SOUTH HOLLAND DISTRICT COUNCIL

Purpose: To consider Planning Application H23-0653-26

Description: Dropped kerb to front of property forming vehicular access and concrete hardstanding.

Location: 1 GREEN BANK WHAPLODE DROVE SPALDING

REV		DESCRIPTION	DATE
PROJECT:		DROPPED KERB AND HARD STANDING	
DRAWING:		SITE LOCATION PLAN	DROPPED KERB DETAIL
PROPOSED BLOCK PLAN		HARDSTANDING DETAIL	
SIZE:		A3	CLIENT: Westone Housing Ltd
SCALE		as labelled	DRAWN BY: JC
09/07/2026		APPROVED: CT	SHEET: 0561/25/01

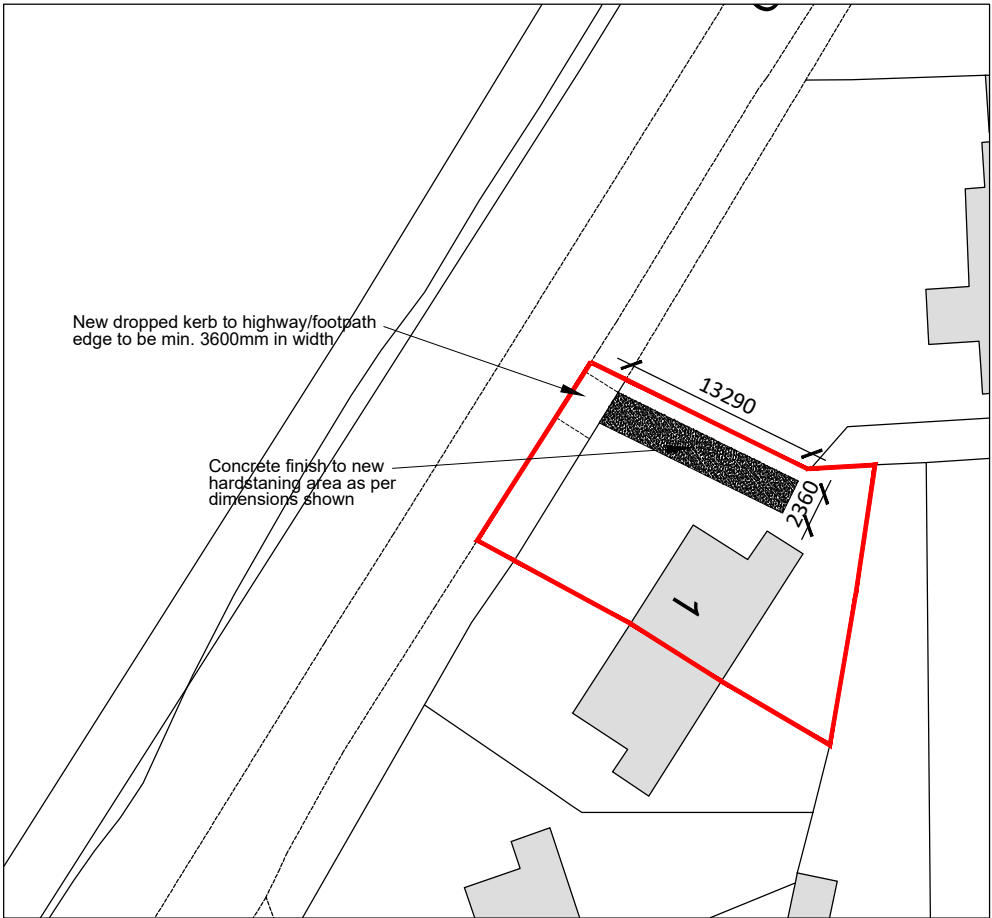
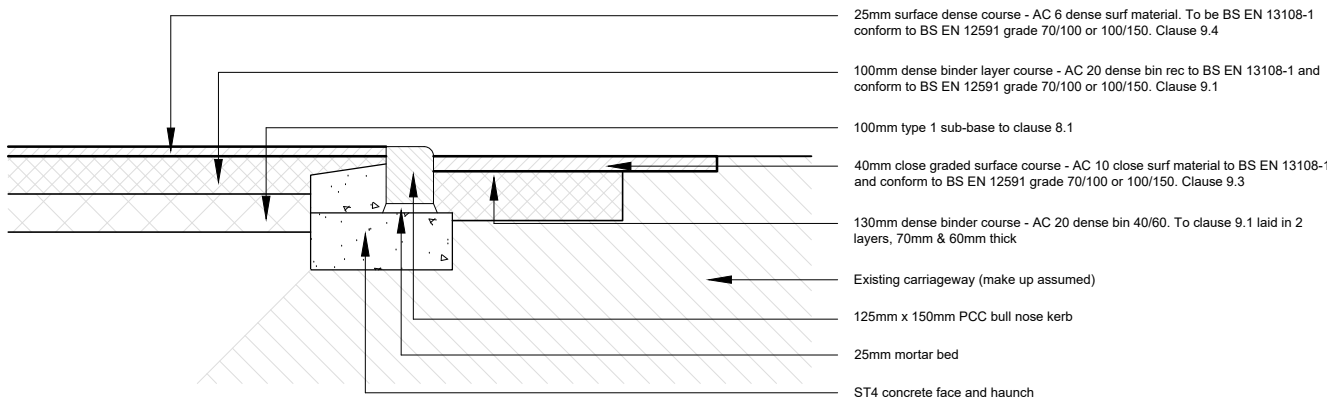
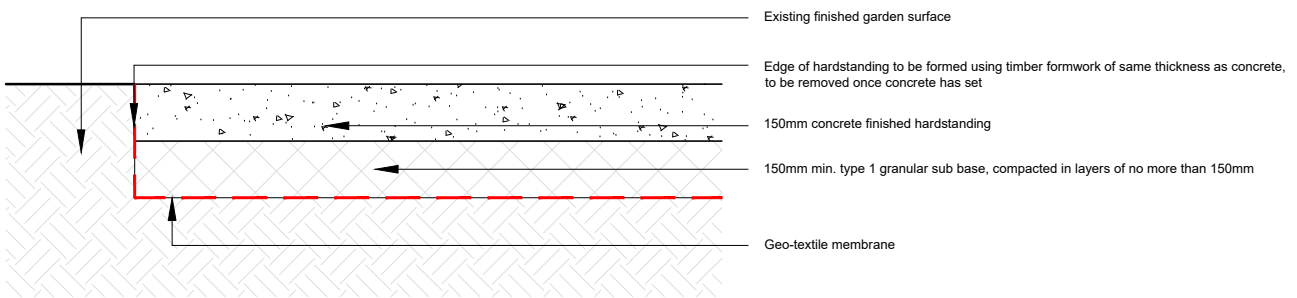
- 6.11 Comments:
- This proposal is for dropped kerb to front of property forming vehicular access & concrete hardstanding. The vehicular access meets the visibility guidelines set out in Manual for Streets. The car parking provided is in line with the guidance set out in Lincolnshire County Councils Design Approach. Therefore, it is considered that this proposal would not result in an unacceptable impact upon highway safety.

- 7.21 The proposed vehicular access would comprise a 3600mm wide dropped access along the highway kerb of Green Bank. Various neighbouring properties, inclusive of those immediately surrounding the application site (3 & 4 Green Bank and Emsted), feature dropped kerbs to allow for vehicular access, and as such, this feature is fairly commonplace within the vicinity of the site.

- 7.22 The vehicular access would lead to an area of hardstanding, which would comprise around 13290mm by 2360mm, located to the front of the dwelling, and would run a significant extent of the length of the front garden area. This area would feature a concrete finish. It is noted that the dwellings in the immediate area mostly feature gravelled driveways, with concrete hardstanding being less typical. However, the introduction of concrete hardstanding would not cause a significant or unacceptable addition, in this instance.

- 7.50 Therefore, in line with Policy F5(2)(ci) and F6(2)(a), there is no need to apply the exceptions or sequential tests. In any event, the site is within Flood Zone 1 and an area of no hazard within the South Holland Strategic Flood Risk Assessment. The level of hardstanding in this instance is notable; however, suitable levels of permeable material would remain on site to ensure that drainage can suitably continue and not cause adverse harm elsewhere. There would not therefore be any significant harm raised in this regard, and it is not considered that the proposal would materially increase the flood risk for the site and surrounding area.
